Environmental Health Division
1675 W. Garden of the Gods Road
Suite 2044
Colorado Springs, CO 80907
(719) 578-3199 *phone*
(719) 578-3188 *fax*
www.elpasocountyhealth.org

Hale Sand, AL-18-029

Please accept the following comments from El Paso County Public Health regarding the sand mining expansion project referenced above:

SPECIAL USE SITE PLAN

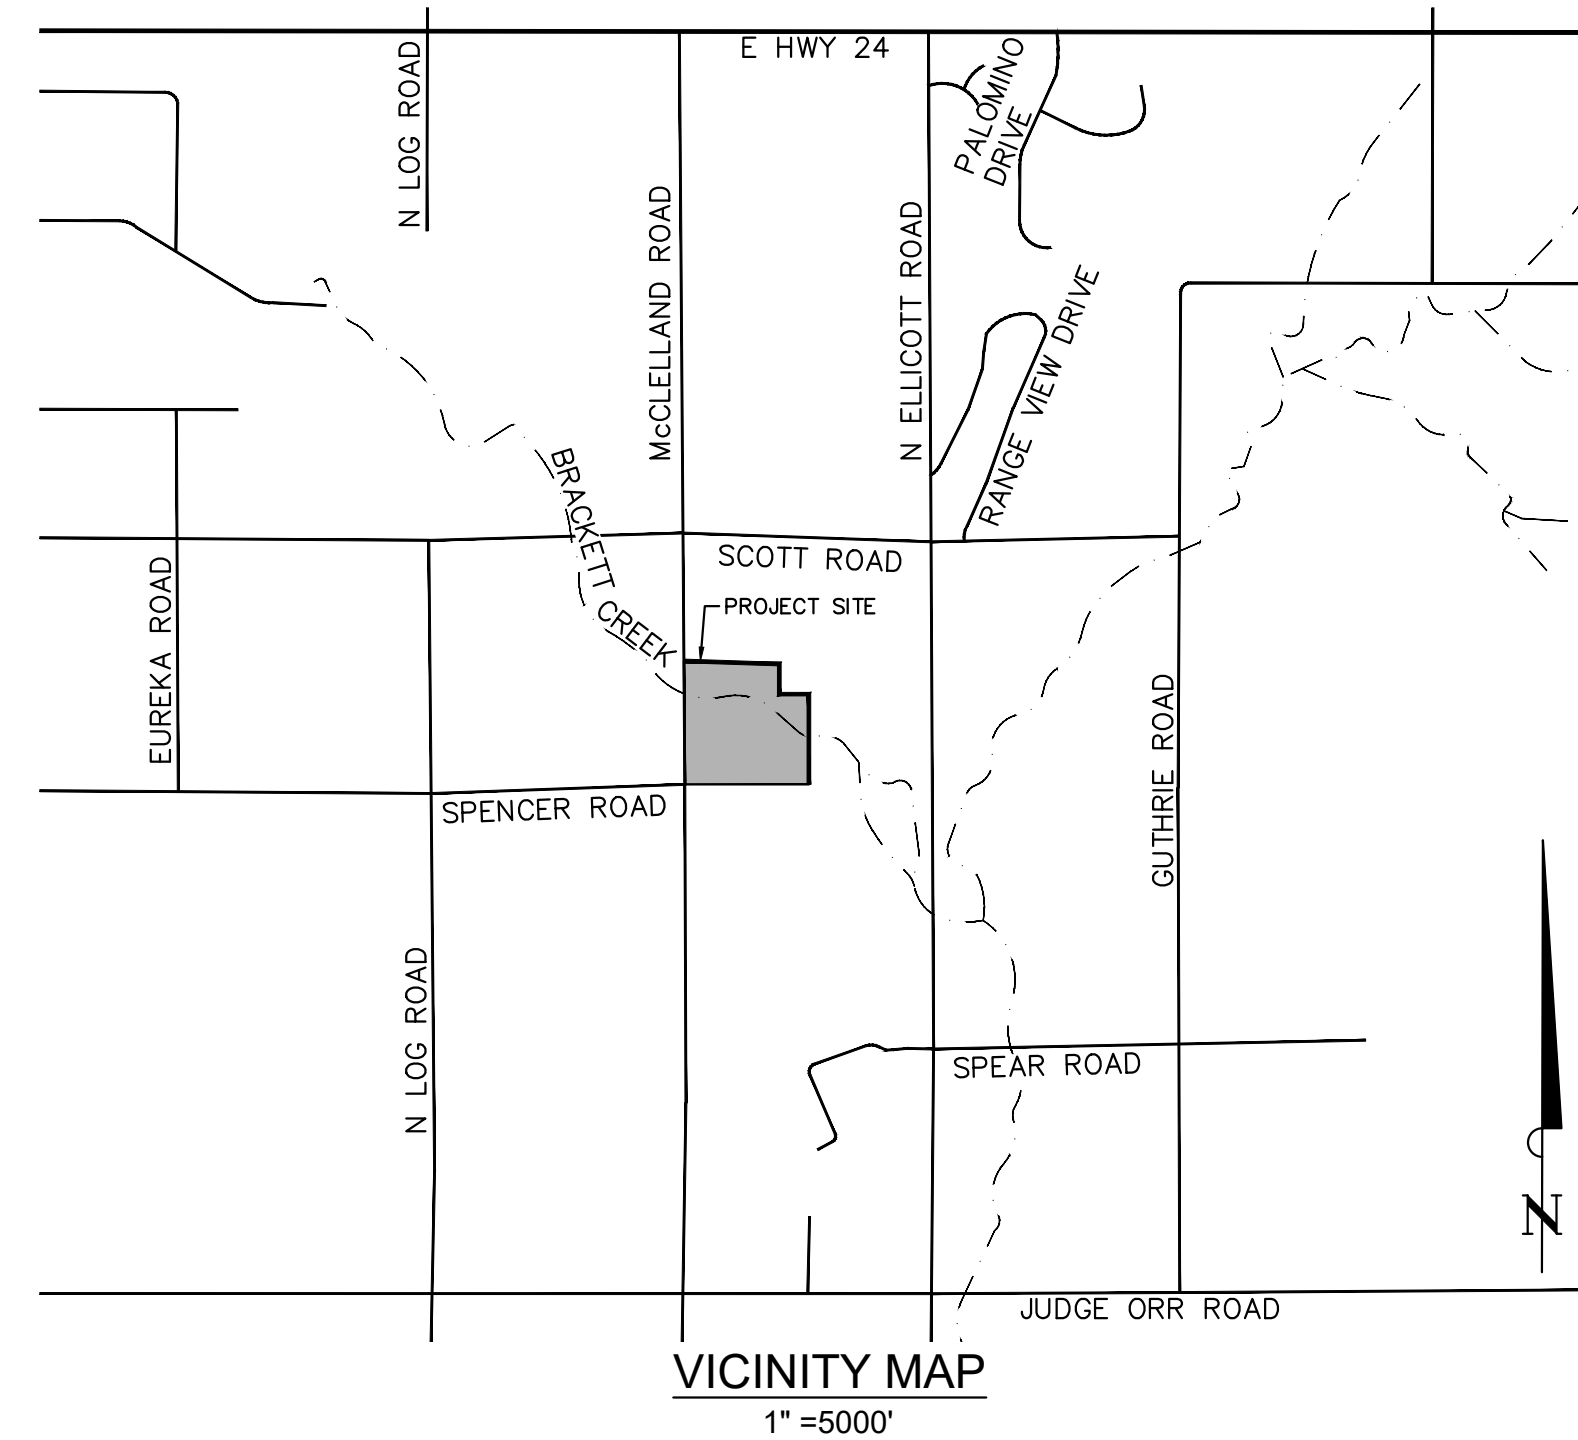
- The proposed water quality detention basin that will capture diverted flows and release storm water at historical rates into Brackett Creek must be designed to completely drain to help minimize mosquito breeding habitat and the potential for West Nile Virus.
